## Vattenfall Norfolk Vanguard

### **Oulton Parish Council's submission at Deadline 5**

Oulton Parish Council (OPC) wish to comment on the Deadline 4 responses received by PINS, as part of its Deadline 5 submission, in relation to traffic and transport issues generated by the project in and near the parish of Oulton.

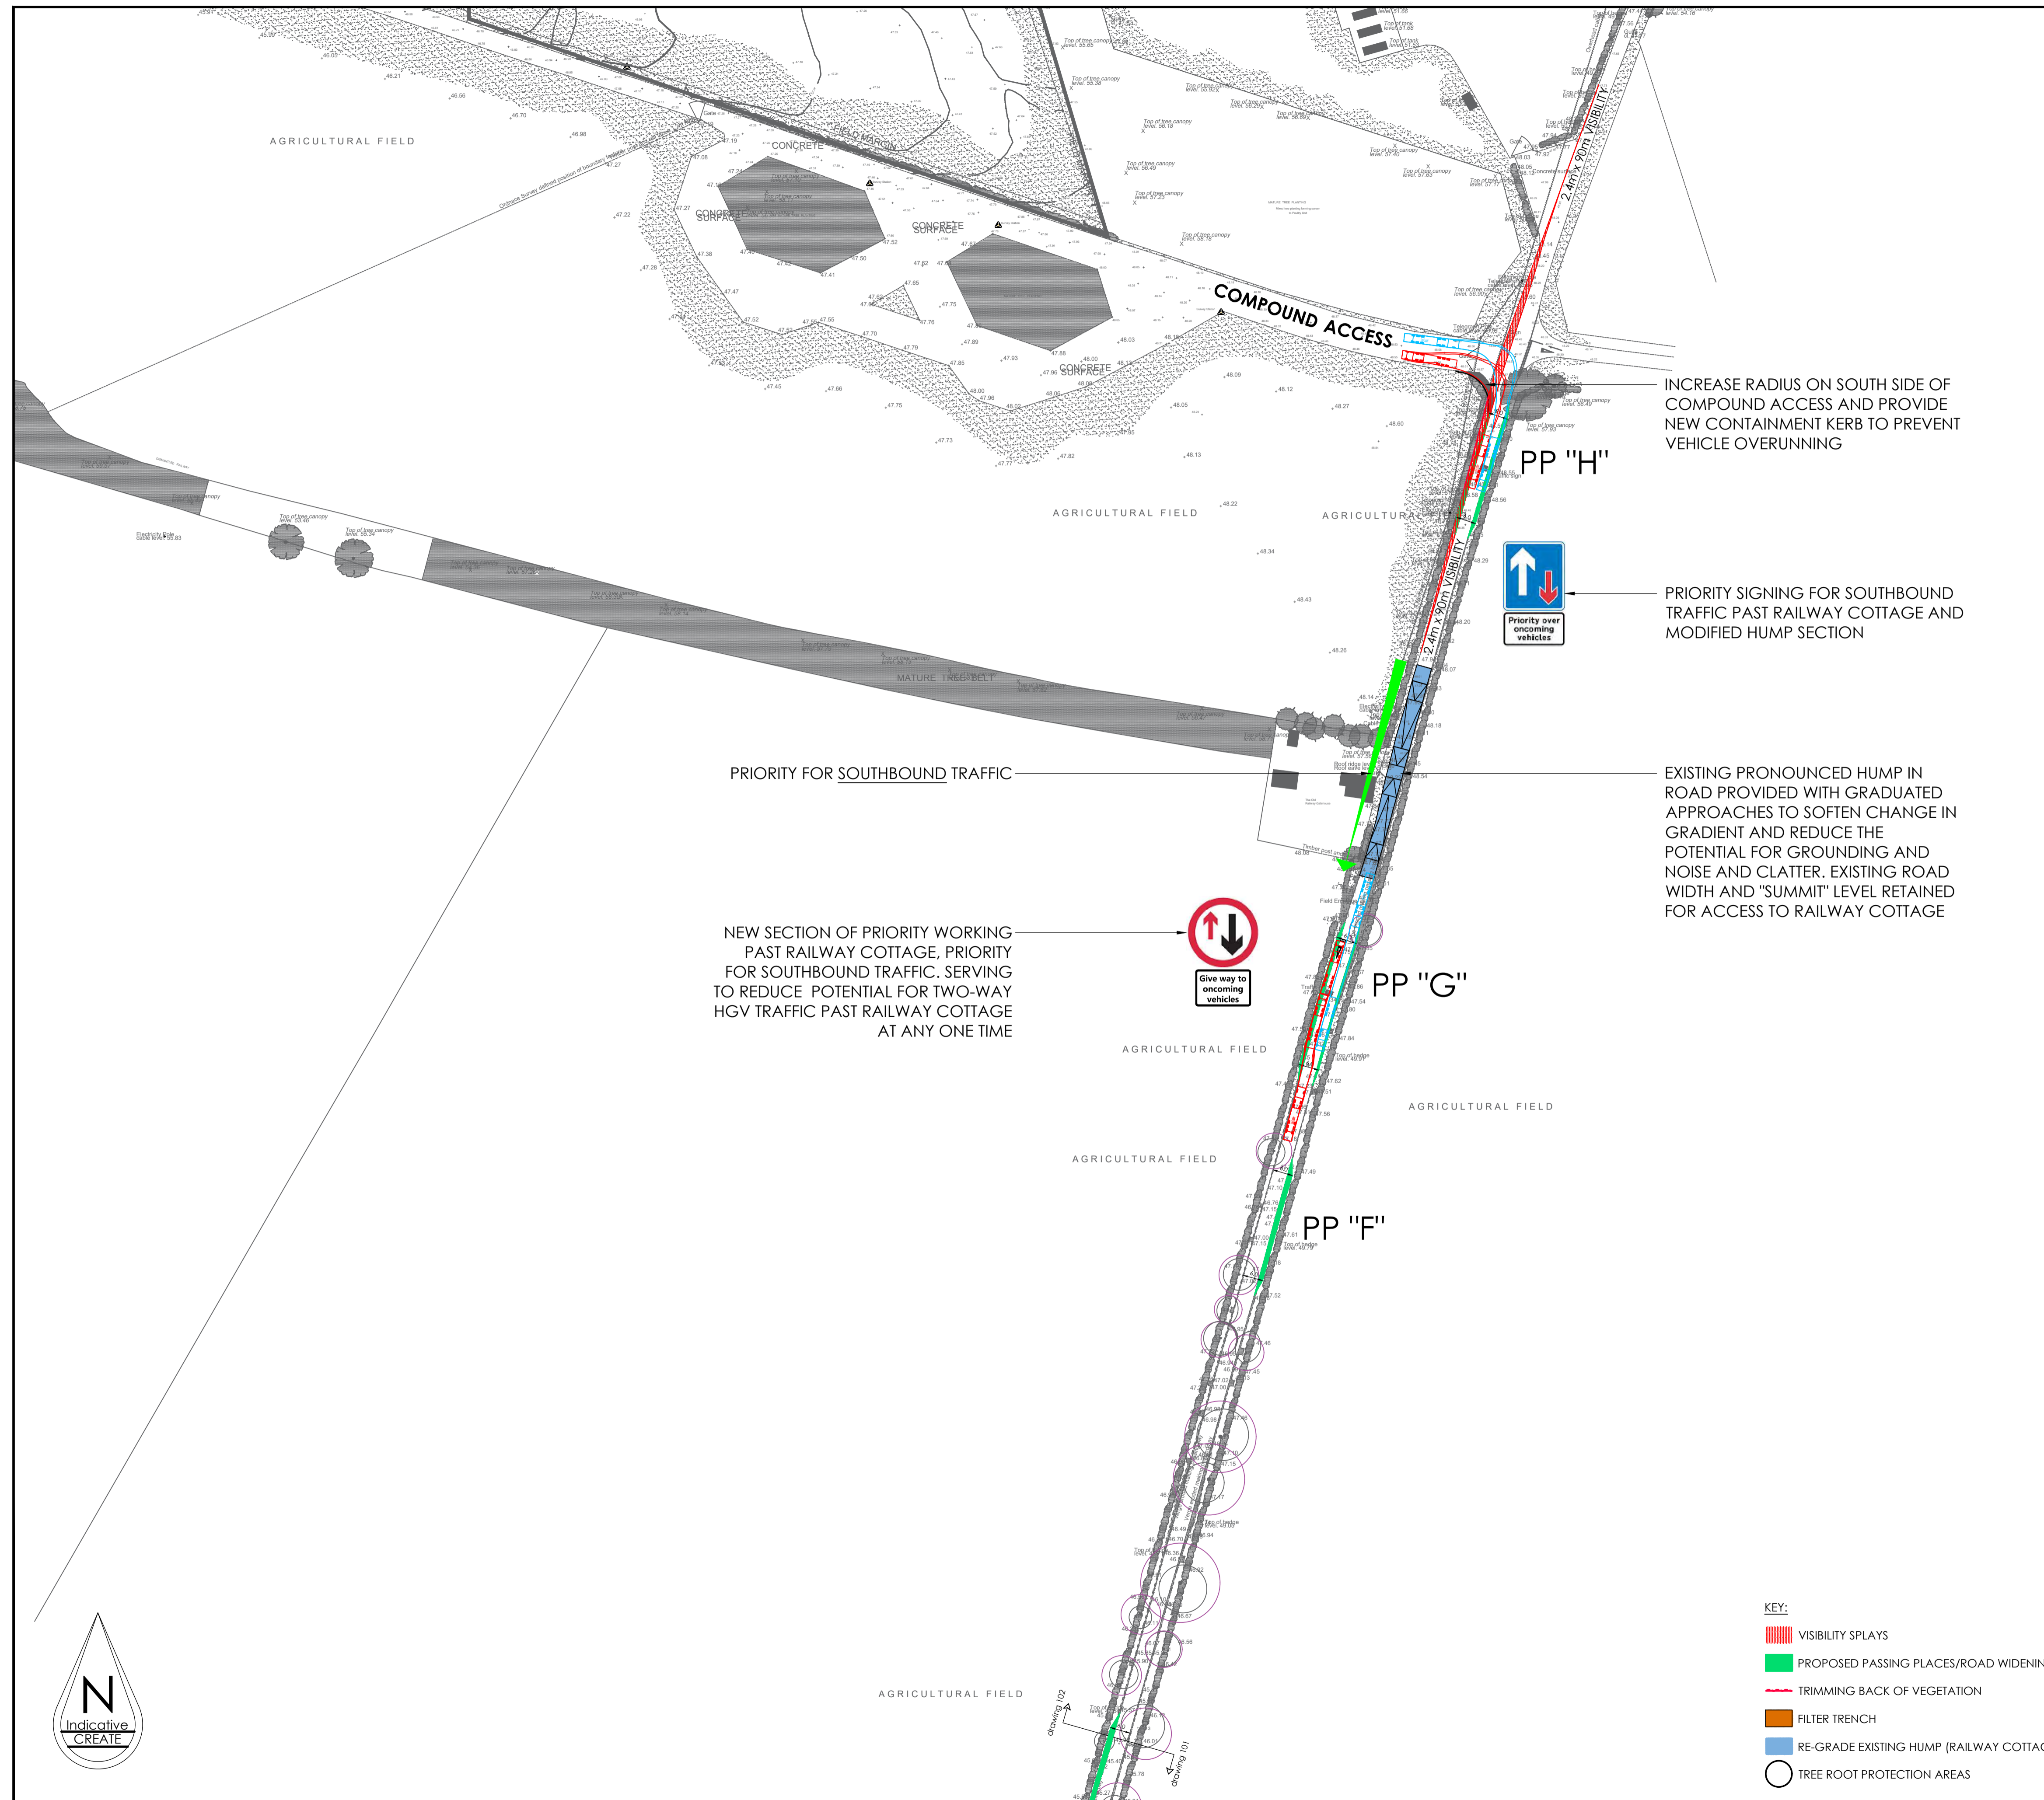
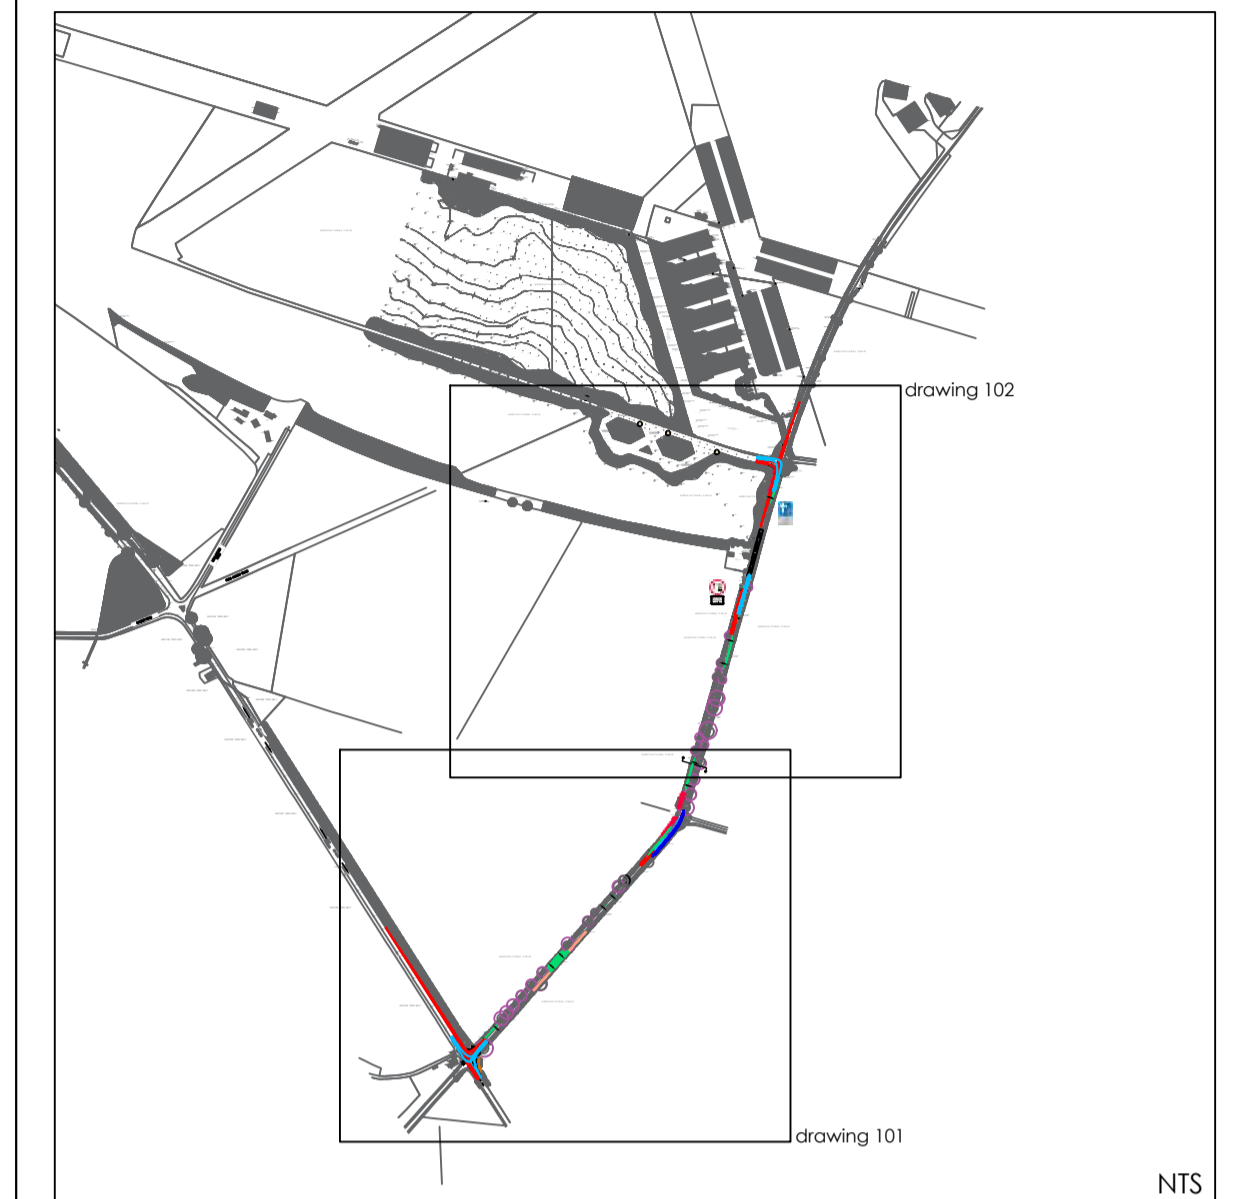
1. **The Old Railway Gatehouse 'hump'.** The applicant has stated that they will implement the same road intervention schemes and the mitigation for the Old Railway Gatehouse as proposed by Orsted Hornsea Three, but to date have not documented this.

After the re-grading and smoothing of the hump, the road will remain the same width with priority signage. Only one vehicle will be able to cross at a time. The re-surfacing of the road has been put forward as mitigation by Orsted as a residential amenity issue to reduce the noise levels at The Old Railway Gatehouse but it should be noted that the smoothing of the hump is also to prevent grounding of HGV low loaders.

It remains unclear whether the re-grading of the road hump is only to facilitate site access rather than improving residential amenity, given that the priority signage could easily lead to *increased* noise events for the residents, due to traffic - specifically HGVs - slowing, stopping and starting within close proximity of the Gatehouse.
